**Ann Machado - RE: 118 Congress Street - Permit #2014-00464**

From: **Ann Machado** <AMACHADO@portlandmaine.gov>
Date: Tue, Mar 18, 2014 at 9:13 AM
Subject: 118 Congress Street - Permit #2014-00464
To: sue@archetypepa.com, etheriault@e-tla.com

I have completed my initial zoning review of the building permit. At this point I can't sign off because I need more information.

BUILDING ELEVATIONS
A2.01

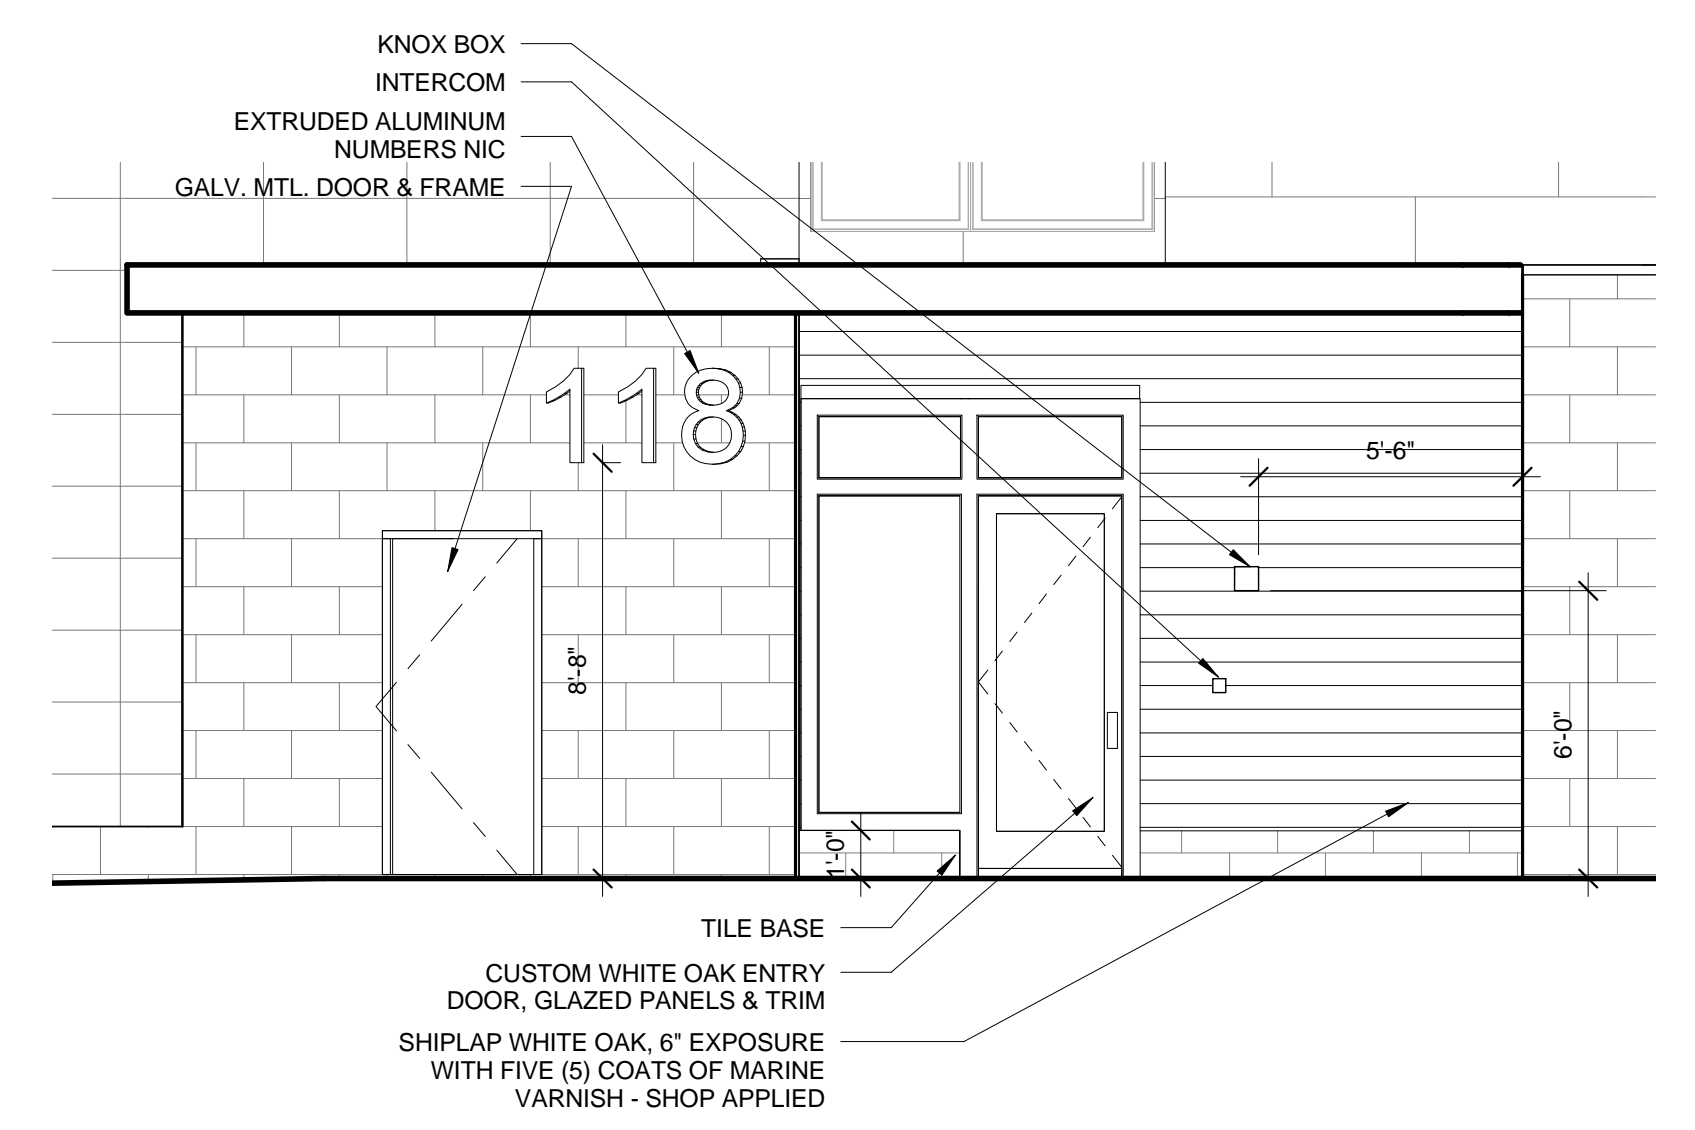
1. The building permit cannot be issued until a demolition permit is applied for and issued for the existing building.
2. The site plan (C1.2) does not show the overhangs.
3. The maximum building height is 50 feet. I need clarification on the average grade because it appears to slope down from the front of the lot to the rear. Also there appear to be sections of the roof that are higher than other sections.

The average grade of our building is taken by the four corner average grade. NW corner 147.45' + NE corner 147.15' + SE corner 147.25' + SW corner 145.00' = 588.5' / 4 = 146.71' (146'-8 1/2") average grade
The allowable building height, measured to the top of the roof truss is 146'-8 1/2" + 50' = 196'-8 1/2". Our building is designed not exceeding this dimension. The sections of the roof that appear higher than other sections as described in your previous email are only parapet walls. The main roof is all at one level.
